## DELEGATED HOUSEHOLDER DECISION

<b>Decision:</b> 12-10-2005	Approved
60494/APP/2005/1543	47 CHERRY ORCHARD WEST DRAYTON ERECTION OF A SINGLE STOREY SIDE AND REAR EXTENSION
<b>Decision:</b> 20-07-2005	Refused
60494/APP/2005/1014	47 CHERRY ORCHARD WEST DRAYTON ERECTION OF SINGLE STOREY FRONT, SIDE AND REAR EXTENSIONS (INVOLVING DEMOLITION OF EXISTING GARAGE AND PLAYROOM), 2 PARKING SPACES TO BE PROVIDED TO FRONT OF PROPERTY
<b>Decision:</b> 20-05-2005	Refused

TITLE:		
PROPOSED FLOOR PLANS		
STATUS	DESIGNED BY	
PLANNING	V.P	
DATE	Page size:	SCALE
01/09/2023	A2	1:50
DRAWING NUMBER	REVISION	HEET NO.
47CO/UB7/106	B	6

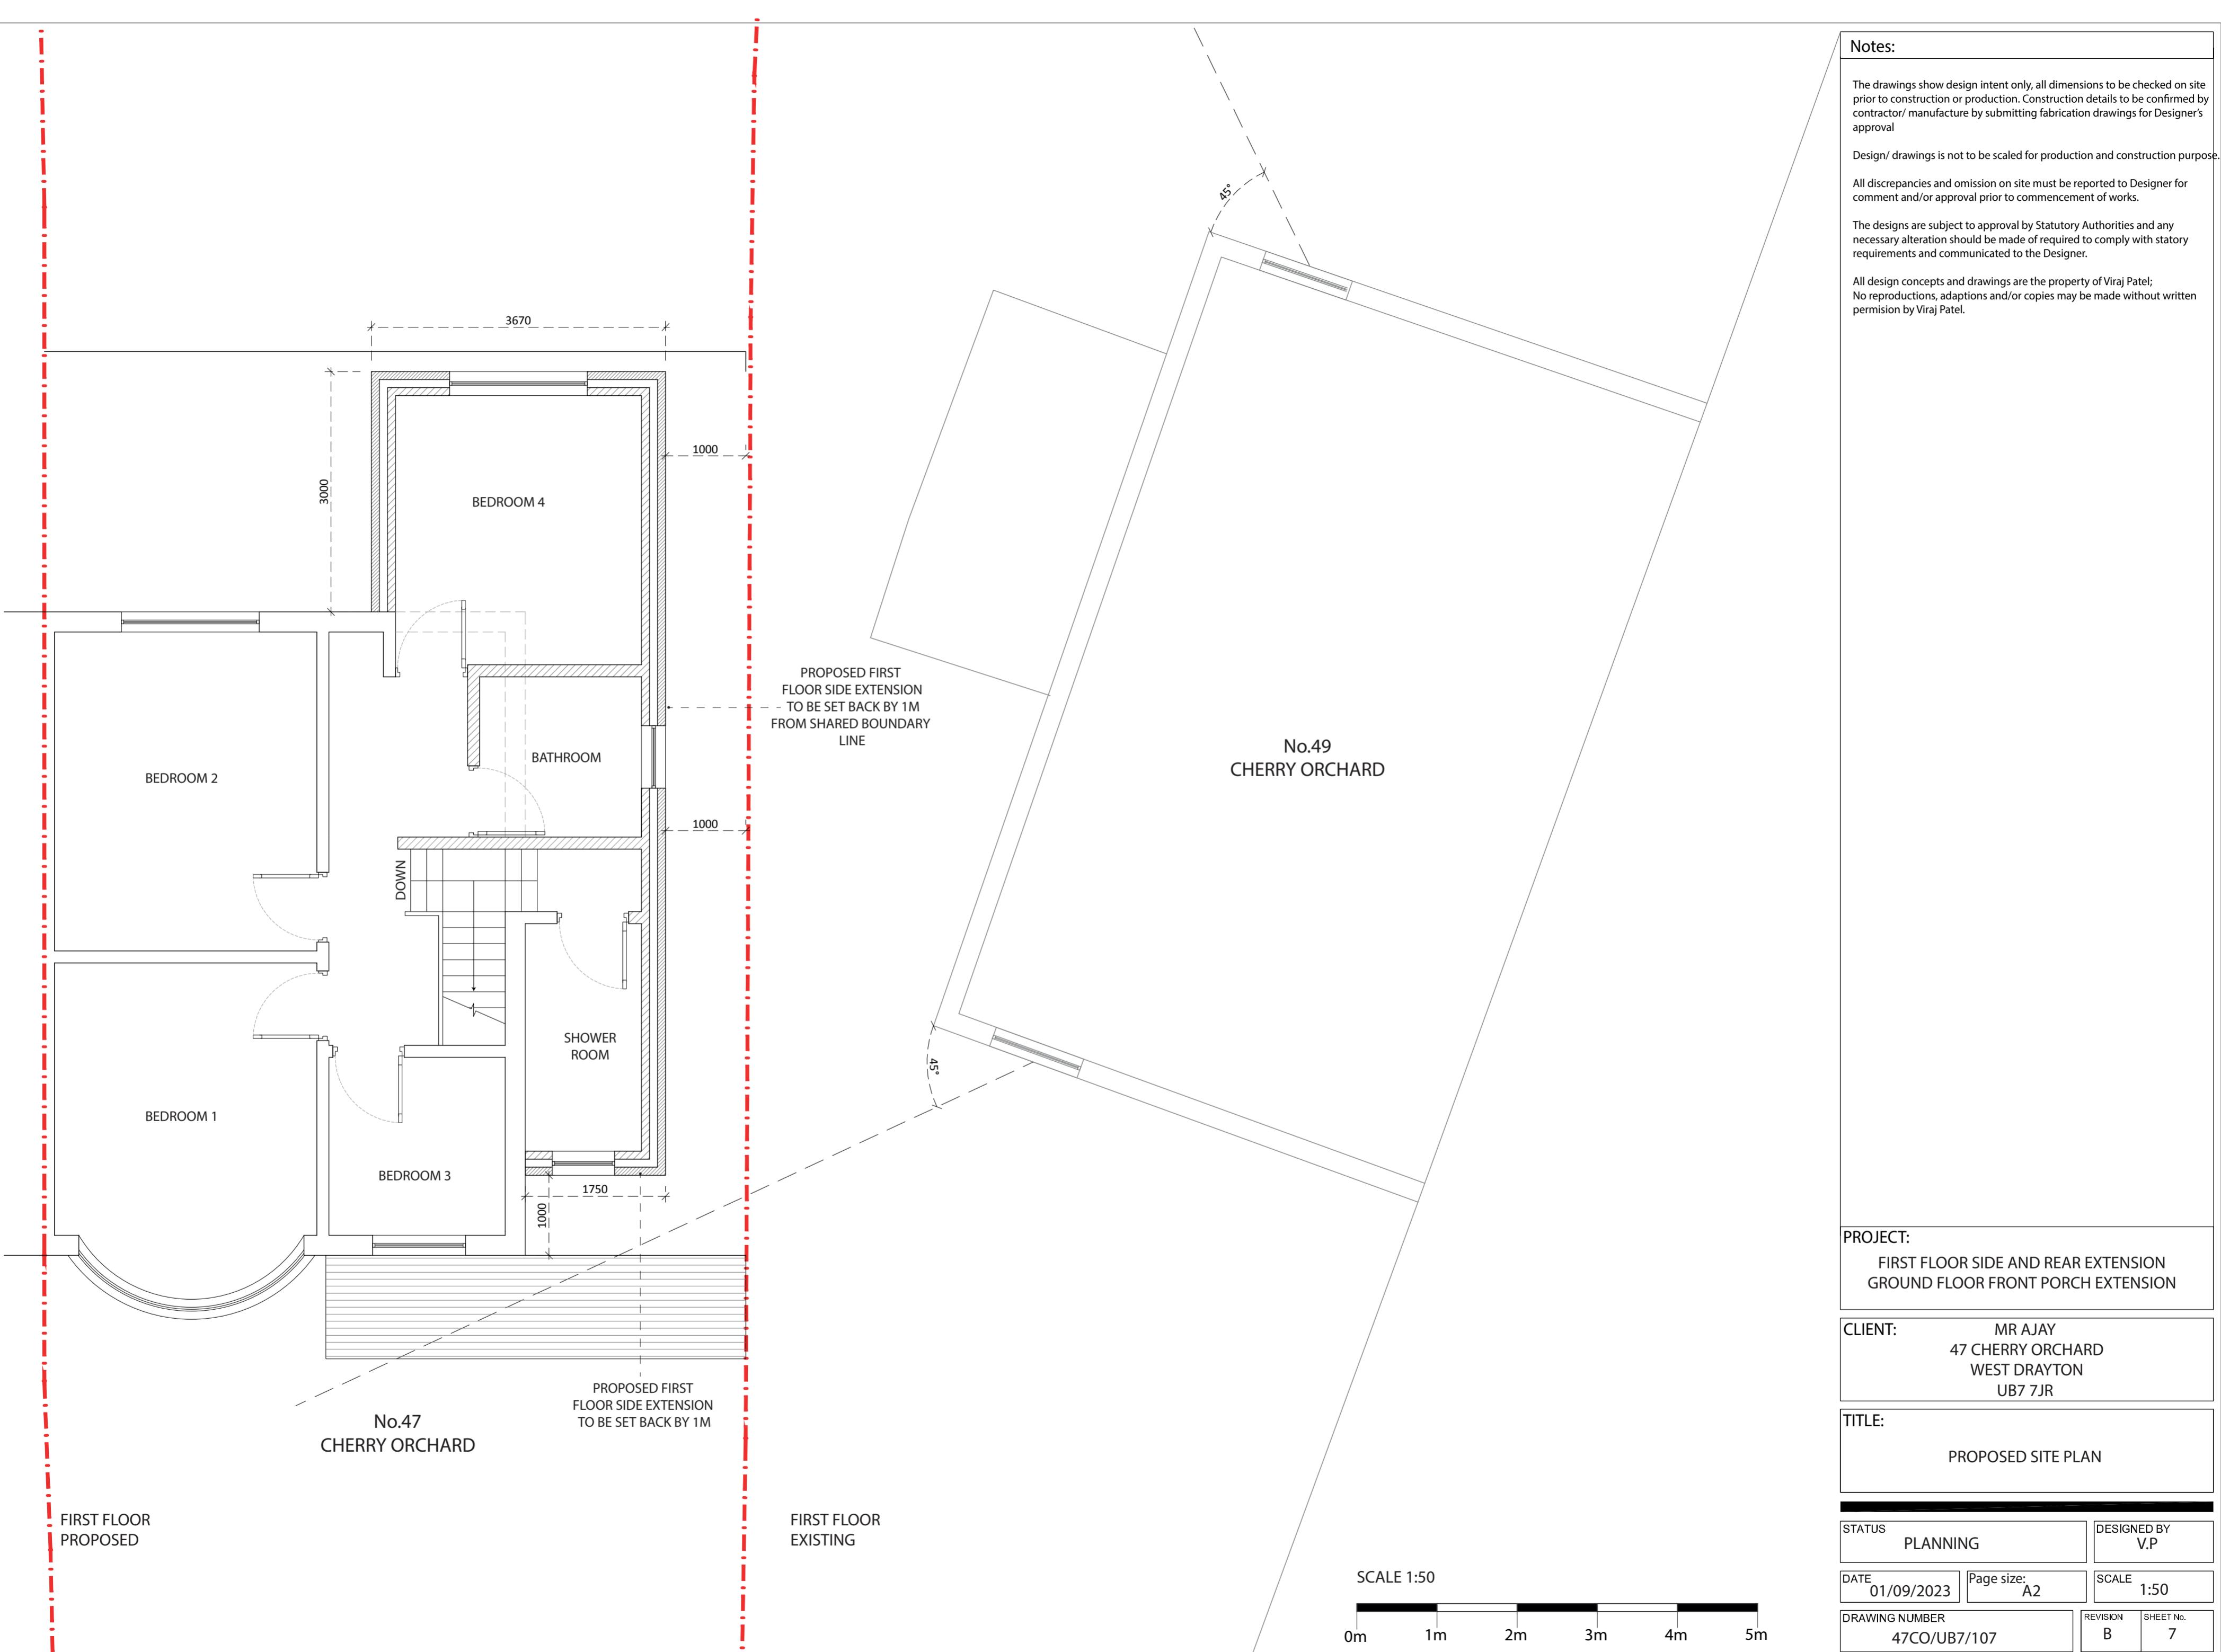
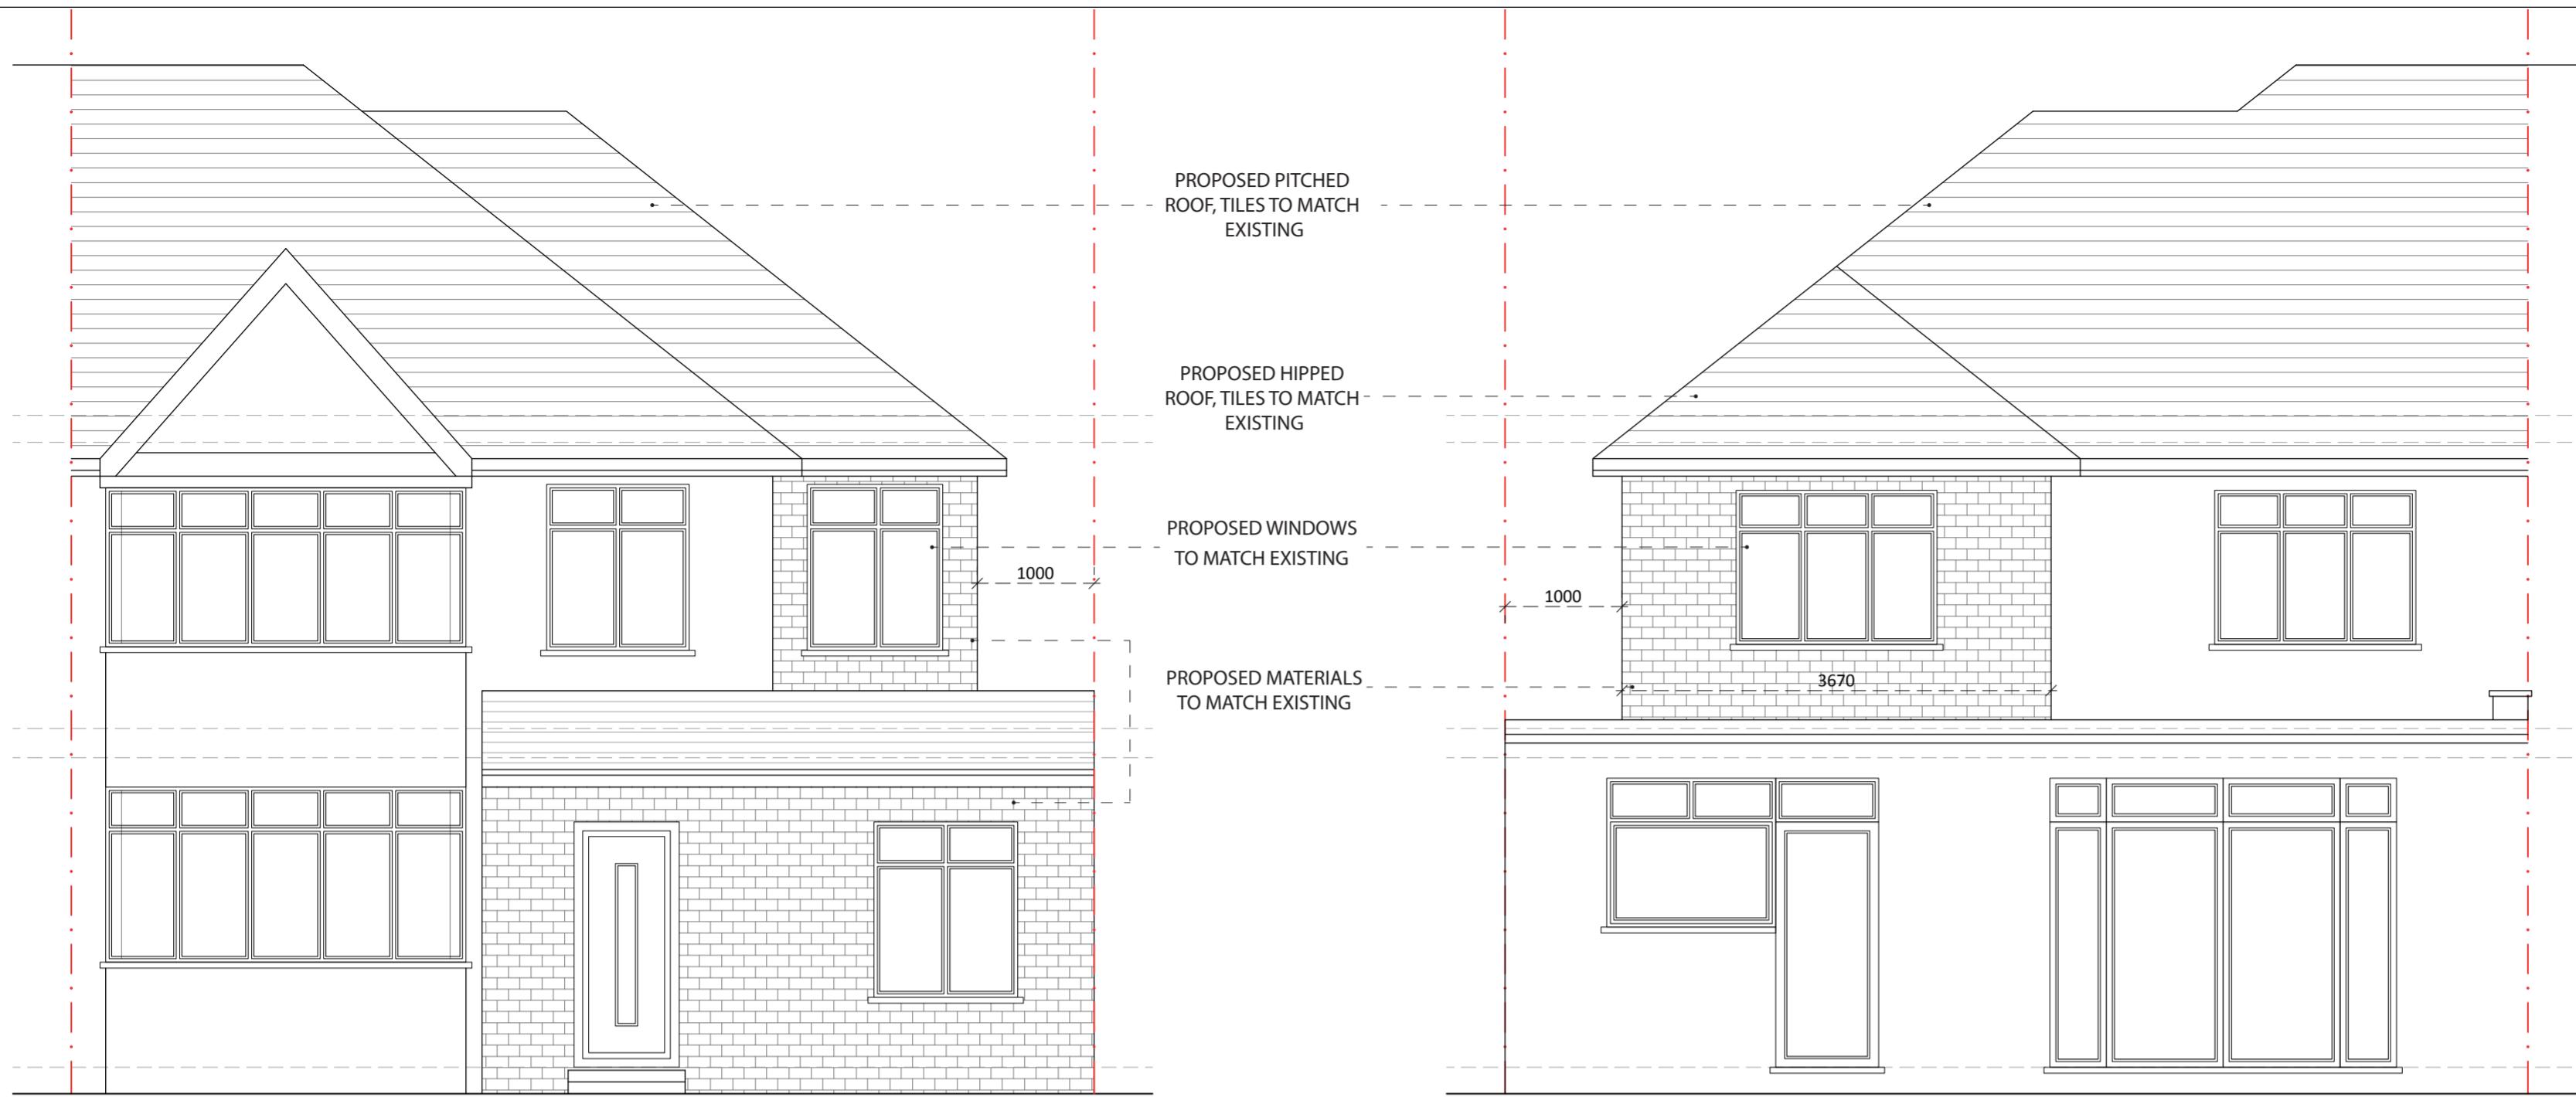
The proposed single storey front extension would extend approximately 1.2m from the principal elevation and would not extend beyond the existing depth of the front porch structure. Whilst the front porch would be visible from the public realm, notwithstanding its single storey nature and modest scale, it is considered to have a detrimental impact on the character and appearance of the existing dwelling. In combination with the existing porch it would dominate the front elevation and represent poor design, detracting from the street scene.

The proposed first floor development would be built directly on the boundary, resulting in a terracing effect. The applicant has declined to set this element back by 1m in line with policy. Given the lack of a set back from the side boundary, the proposed development would fail to respect the architectural character and appearance of the existing dwelling and the surrounding area. No properties along this part of Cherry Orchard which have been extended in a similar way. Furthermore, if a gutter was added the extension would oversail the boundary, further emphasizing its excessive scale.

<b>TITLE:</b> PROPOSED ELEVATIONS	
<b>STATUS</b> PLANNING <b>DESIGNED BY</b> V.P	
<b>DATE</b> 01/09/2023 <b>Page size:</b> A2 <b>SCALE</b> 1:50	
<b>DRAWING NUMBER</b> 47CO/UB7/108 <b>REVISION</b> B <b>HEET No.</b> 8

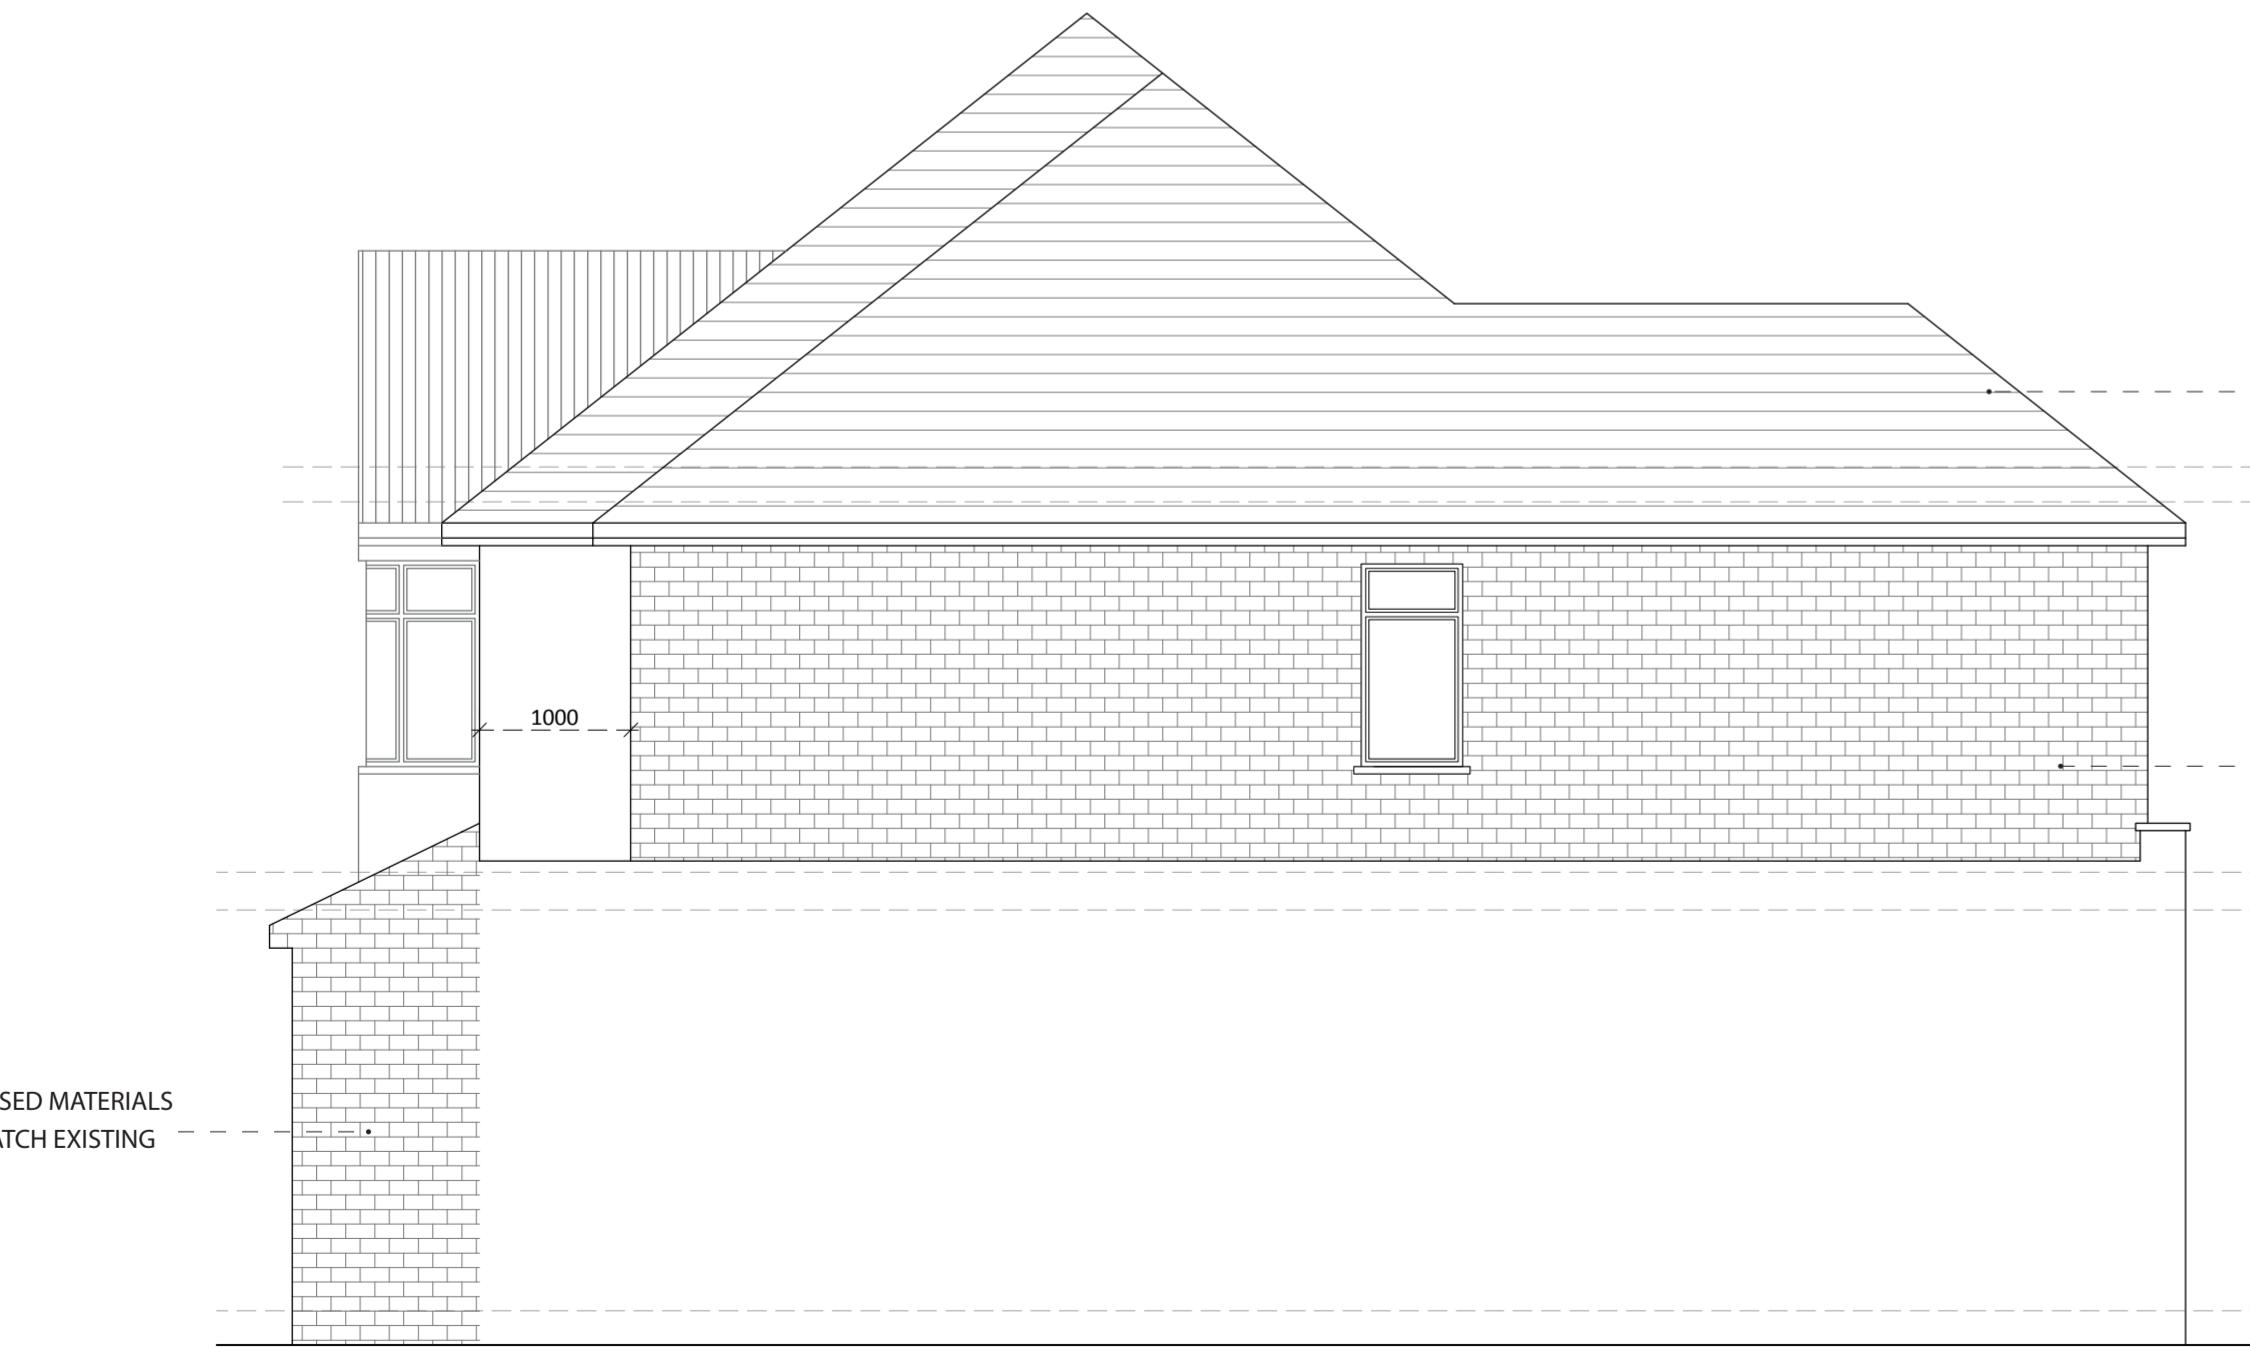
The proposed first floor side/rear extension would be built on the shared side boundary with the neighbouring property at No.49 Cherry Orchard and would not extend beyond the rear build line of this neighbour. One first floor side facing window is proposed to face towards No.49 however, this window would serve a non-habitable room (bathroom). To ensure no adverse impact on loss of privacy, an obscure glazing condition could have been secured to this window if the application were approved. Whilst noting that a first floor side window is identified at No.49, this window is considered a secondary window as the main source of light would be provided at the front and rear elevations. Furthermore, the plans illustrate that the plans would not intrude into the 45-degree line at 1st floor level. Due to orientation and separation distance, it is not considered to have a detrimental impact on loss of sunlight/daylight, loss of privacy or would appear visually overbearing to No. 49 Cherry Orchard.
